Our Ref: 718742  
DPIE Ref: DA220-07-2002-I-Mod-12  
RFI Ref: RFI-35384212

**RESPONSE TO REQUEST FOR ADDITIONAL INFORMATION – MODIFICATION TO DEVELOPMENT CONSENT  
DA220-07-2002-I-Mod12, 1 DAMPIER STREET, BOWMAN NSW**

On behalf of the applicant, Teys Australia Southern Pty Ltd, please find below a formal response to the request for additional information provided by the Department on 01 February 2022. The below response adopts the points outlined within Attachment 1 of the request.

3D VIEW LOOKING SOUTH WEST FROM DAMPIER STREET
NOT TO SCALE

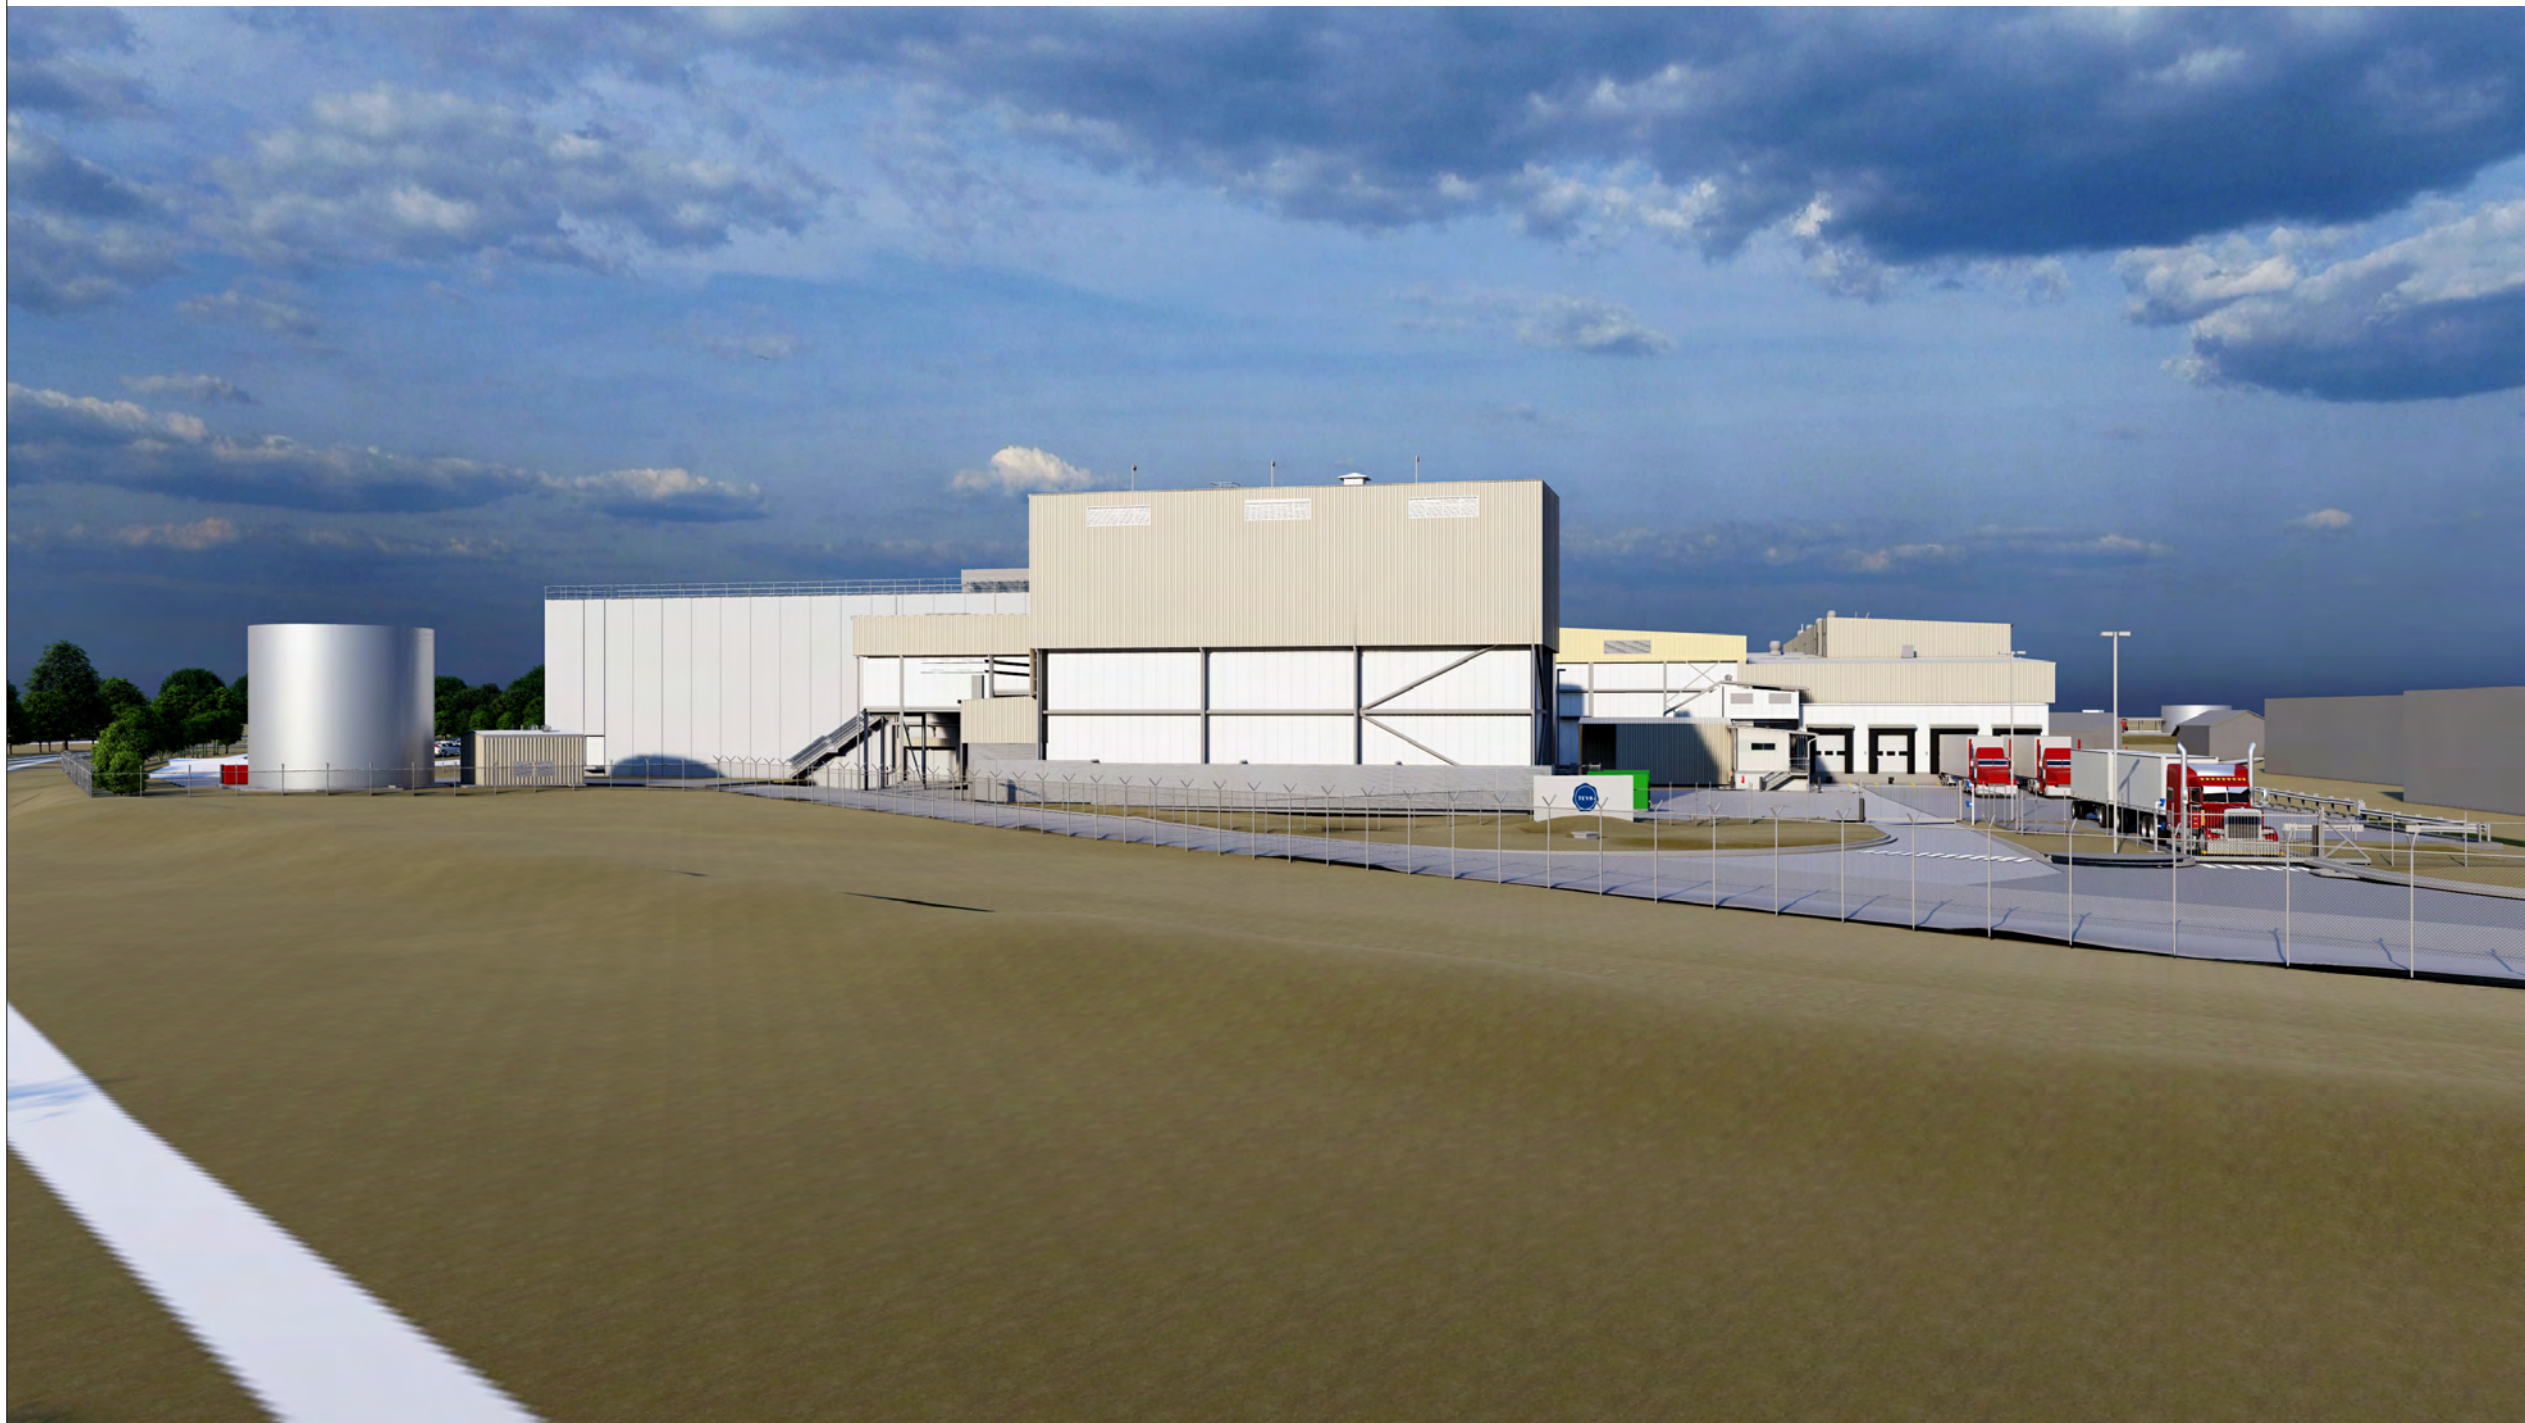
The proposed works include the construction of two buildings, with one building (Plate Freezer) over 18.5m in building height, yet the Report states “the proposed modification will be negligible in terms of potential visual impacts derived from any additional building height, bulk or scale”. Further details should be provided to confirm the visual relationship between the proposed works and the existing buildings and, if necessary, an assessment of potential visual impacts from public vantage points (e.g. Byrnes Road).

Elevation plans and 3D perspectives have been provided to support the assessment of the visual impact. The design, scale and bulk of the new Plate Freezer / Store complements the existing development and does not result in any adverse visual impacts.
